**WELWYN HATFIELD BOROUGH COUNCIL
EXECUTIVE DIRECTOR - PLANNING, PUBLIC PROTECTION AND GOVERNANCE**

DELEGATED APPLICATION

Application No: 6/2019/1089/HOUSE
Location: 50 Plough Hill Cuffley Potters Bar EN6 4DS
Proposal: Erection of a ground floor rear/side and first floor extension, including the construction of a rear dormer and installation of rooflights to facilitate the creation of habitable space within the loft
Officer: Ms Lucy Hale

PROPOSED FRONT ELEVATION

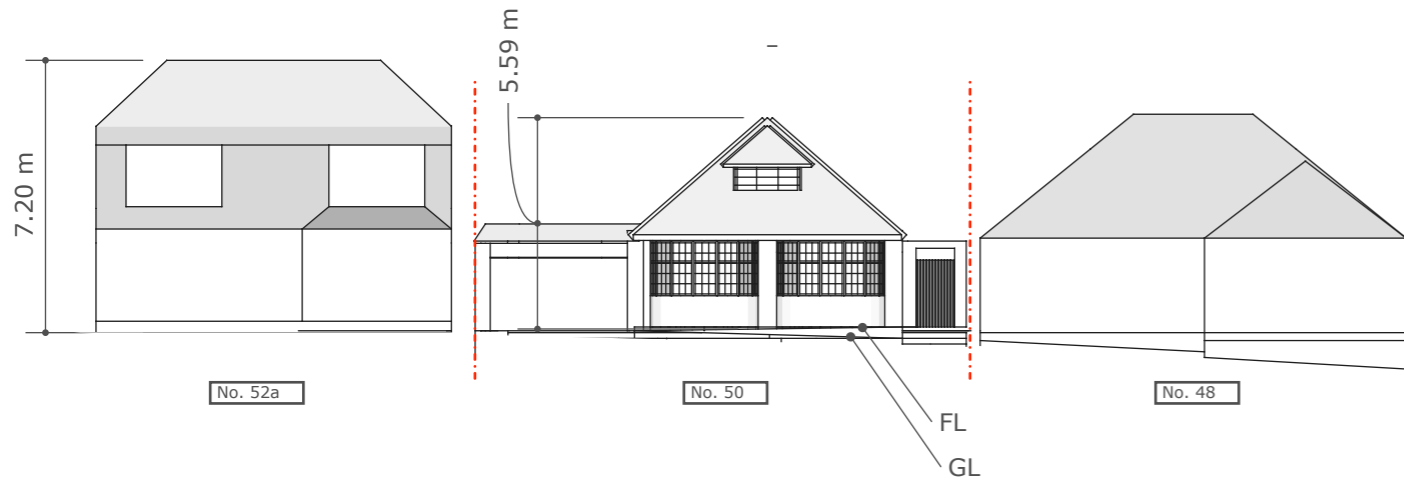
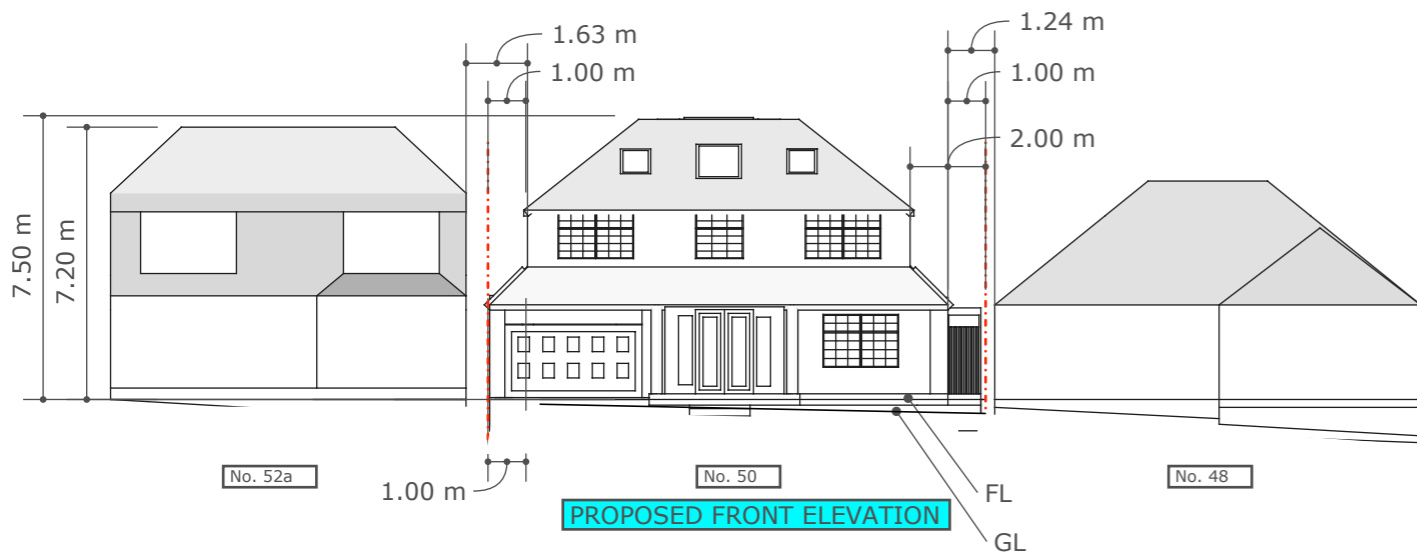
The general pattern of the area relates well to the topography of the land, with the height of the properties set in line or lower than their neighbouring property, which are located on a higher land level. There are examples where properties deviate from this, however, the difference in height is minimal and not overly prominent within the streetscene. The ridge height of the dwelling would increase to approximately 7.5 metres. No.52A Plough Hill, neighbouring the site, is a two storey dwelling which measures approximately 7.2 metres and therefore the application dwelling would be marginally higher by approximately 0.3 metres. Whilst the dwelling sits on a lower ground level but would measure higher than the neighbouring property, the proposed height of eaves and first floor windows would sit in line with No.52A and the hipped roof design would reduce the bulk and massing to the roof. The resultant dwelling would sit noticeably higher No.48, which is a bungalow.

Although the resultant dwelling would appear more apparent within the streetscene as a result of its increase in height and size, it is not considered to be out of keeping or appear unduly prominent. Furthermore, the dwelling is set back from the highway by approximately 20 metres and mature trees along the verge assist with screening the property particularly when travelling north along Plough Hill.

A crown roof is proposed which is a design feature present in the wider area and therefore represents an acceptable form of development. In terms of visual amenity and quality of design, some crown roofs are not attractively designed and can significantly detract from the appearance of a dwelling and the overall character of the area. A section drawing is considered reasonable to condition to show that the flat roof is to be stepped down and concealed behind the surrounding pitched roof.

1. No above ground development shall take place until details of the proposed crown roof, including a cross-section drawing is submitted to and approved in writing by the Local Planning Authority. Subsequently the development must not be carried out other than in accordance with the approved details.

PROPOSED LEFT ELEVATION

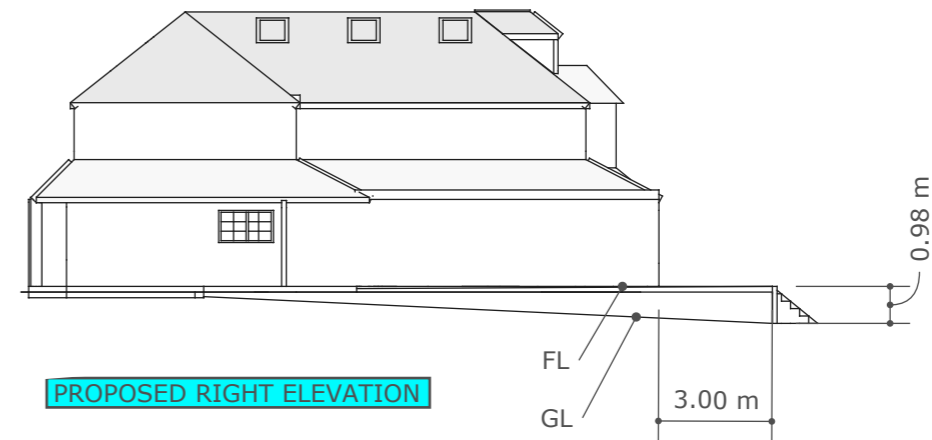
No.48 is located to the south east of the application site and comprises a bungalow. The neighbouring property is set back from the front building line and the properties are currently similar in height. The proposal would result in the dwelling increasing in ridge height by approximately 2 metres and extending further to the rear in line with the rear building line of No.48. Whilst the dwelling would increase in bulk and mass, it would maintain a 2 metre separation distance and as a result of the hipped roof design, would not appear unduly dominant or overbearing. In addition, as a result of the orientation of the dwellings, it is not considered that the extensions would result in a detrimental level of light or overshadowing to habitable windows or the rear garden. Furthermore, there are no first floor side facing windows that would result in a direct overlooking impact.

An objection has been received from No.52A and these comments are summarised above. No.52A is located to the north west of the application site and comprises a two storey detached dwelling which is located 1 metre from the shared boundary and is approximately 1.7 metres higher than the application dwelling. No.52A benefits from a rear extension which is located approximately 2 metres from the shared boundary. The proposed first floor part of the rear extension would sit behind this rear building line of this neighbouring property by approximately 1 metre. The proposal would also result in the property extending closer to the shared side boundary with an approximate 1 metre gap at first floor, which increases to 1.8 metres towards the rear. This increase in distance from the boundary and hipped roof design would assist in reducing the bulk and mass visible from the secondary bedroom window on the rear elevation of No.52A and reducing the degree of overshadowing. It is not considered that the proposed development would appear unduly dominant or result in undue detrimental loss of light to the habitable windows on the rear elevation.

An objection has been raised by No.52A regarding the increase in height and reduction in separation distance particularly in regard to the side elevation window serving a hallway and the resultant outlook and loss of light. Following a site visit, it is noted that this window provides natural light into the hallway at first floor and partly at ground floor. In addition, there are windows at ground floor serving a utility room and downstairs bathroom. Whilst the proposal would result in a change in outlook from the hallway window, as this is not a primary habitable window it is not considered to result in significant harm to living conditions or amenity. Furthermore, whilst it is acknowledged that

In regard to the hallway window, whilst it is acknowledged that the proposal will reduce the natural light entering this window, this window does not serve a primary habitable room. In terms of direct sunlight, the hallway window is located on the south east side elevation of No.52A. As the sun rises, shadows would be cast on to No.52A from the application property, however, as the sun moves round to the west during the late afternoon and evening, the front elevation of the properties would receive the direct sunlight. Whilst it is anticipated there will be a degree of loss of natural light entering the hallway window and ground floor windows serving the bathroom and utility room, as these are not windows serving primary habitable rooms, it is not considered that the proposal would result in a detrimental loss of light that would warrant refusal of the application.

Concern has been raised by this neighbour in regard to potential for further side elevation windows. No first floor side elevation windows are proposed, other than a bathroom window which can be suitably conditioned. If windows were to be inserted at first floor in the future, without planning permission these would be restricted to be obscure glazed and non-opening below 1.7 metres from ground level. Should the applicant wish to insert a clear glazed window, a planning application would need to be submitted in order to assess the potential impact on privacy.

2. Any upper floor window located in a wall or roof slope forming a side elevation of the extension hereby approved must be obscure-glazed and non-opening unless the parts of the window which can be opened are more than 1.7 metres above the floor of the room in which the window is installed, and shall be retained in that form thereafter.
